Yorkshire Water Services
Developer Services
Sewerage Technical Team
PO BOX 52
Bradford
BD3 7AY

Your Ref: 2023/90024
Our Ref: Z000502

George Hotel, St George's Square, Huddersfield - Partial demolition of a listed building to facilitate refurbishment and extension of the George Hotel to form a 90+ room C1 hotel with associated ancillary uses (including bar, restaurant, gym, conference room)

Thank you for consulting Yorkshire Water regarding the above proposed development. We have the following comments:

Title  
 DRAINAGE SURVEY

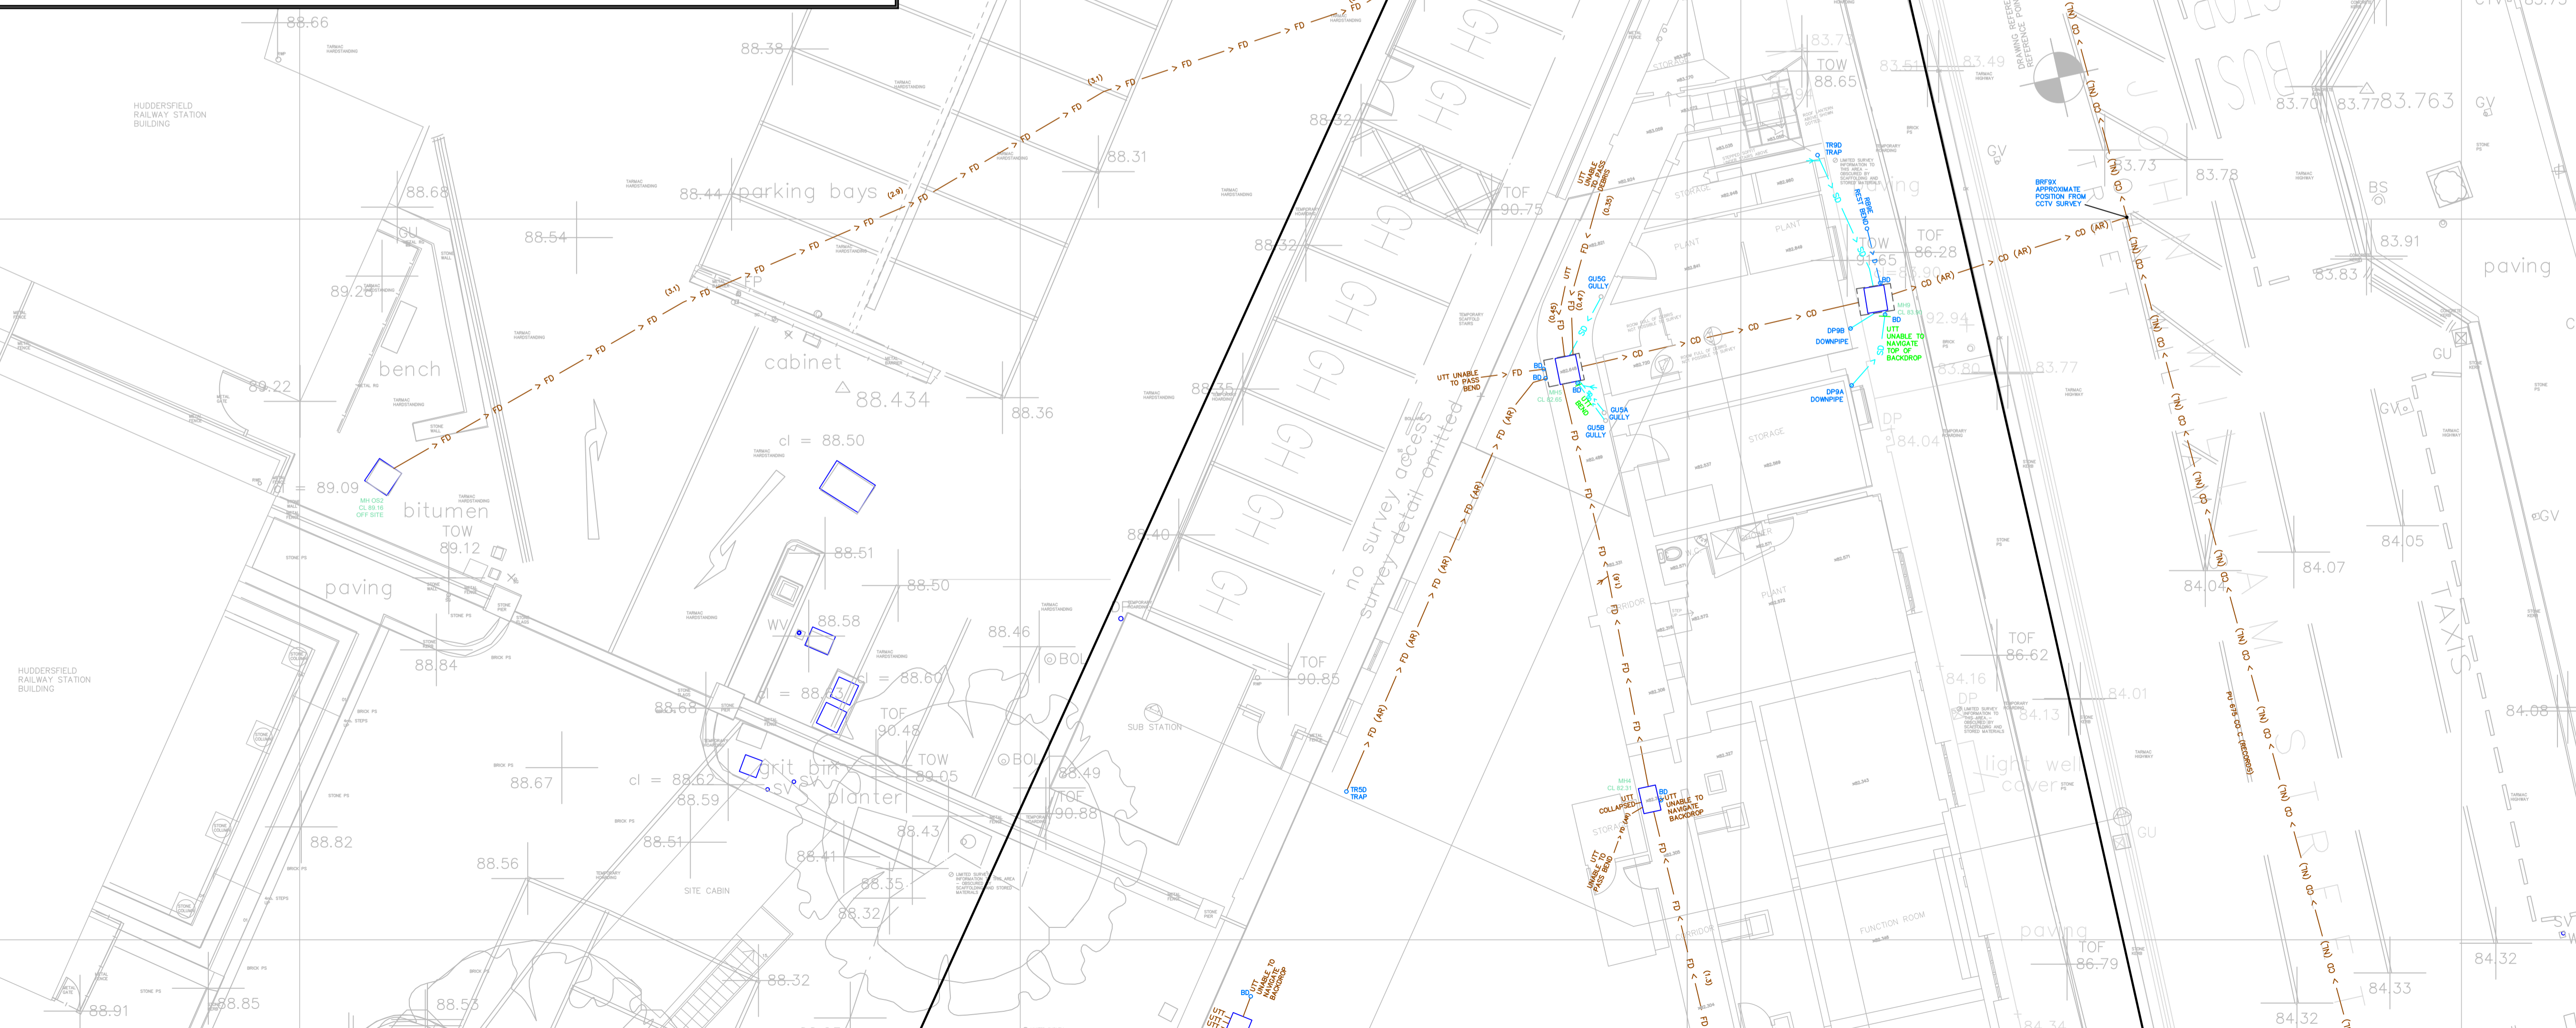
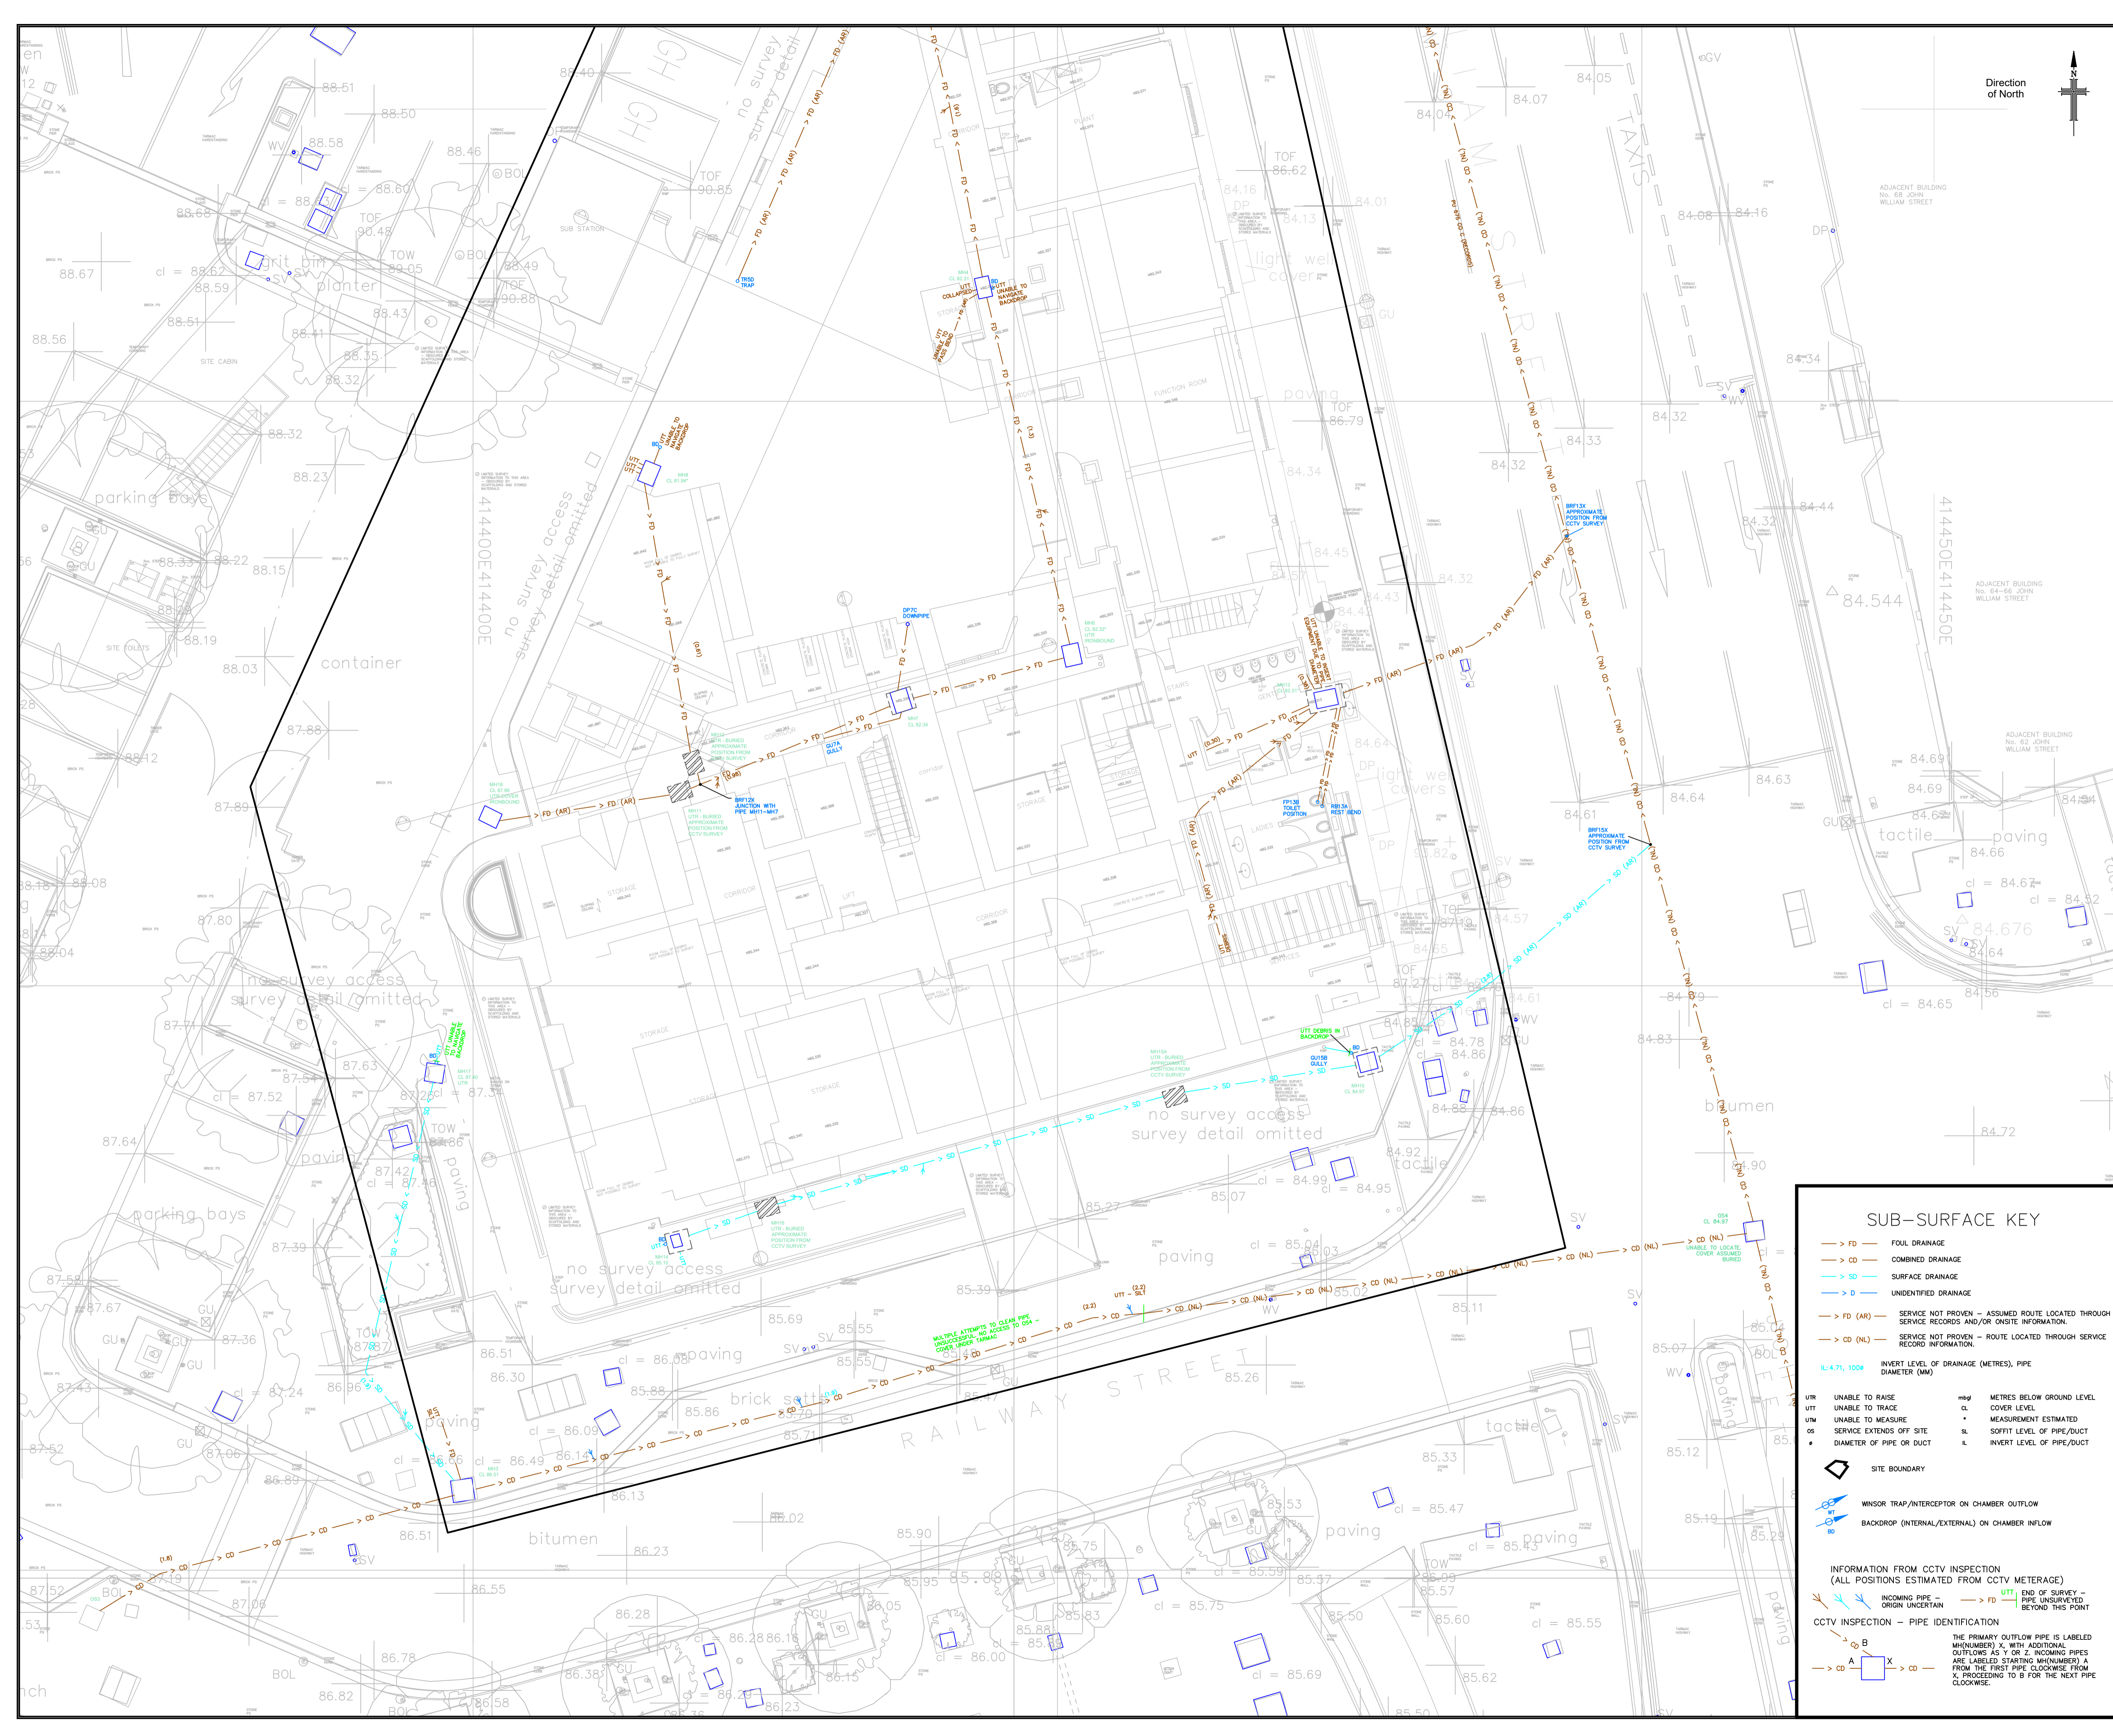
- 1.) This site can be supplied subject to property height and demand, expected pressures are approx. 52m - 57m at ground floor level.
- 2.) 2 x private mains with meters lie within redline boundary. These would need to be disconnected and removed and all costs to be borne by Developer.
- 3.) There may be other private water mains crossing the site for which the Company holds no records.
- 4.) Some off-site main-laying may be required at Developer's cost.
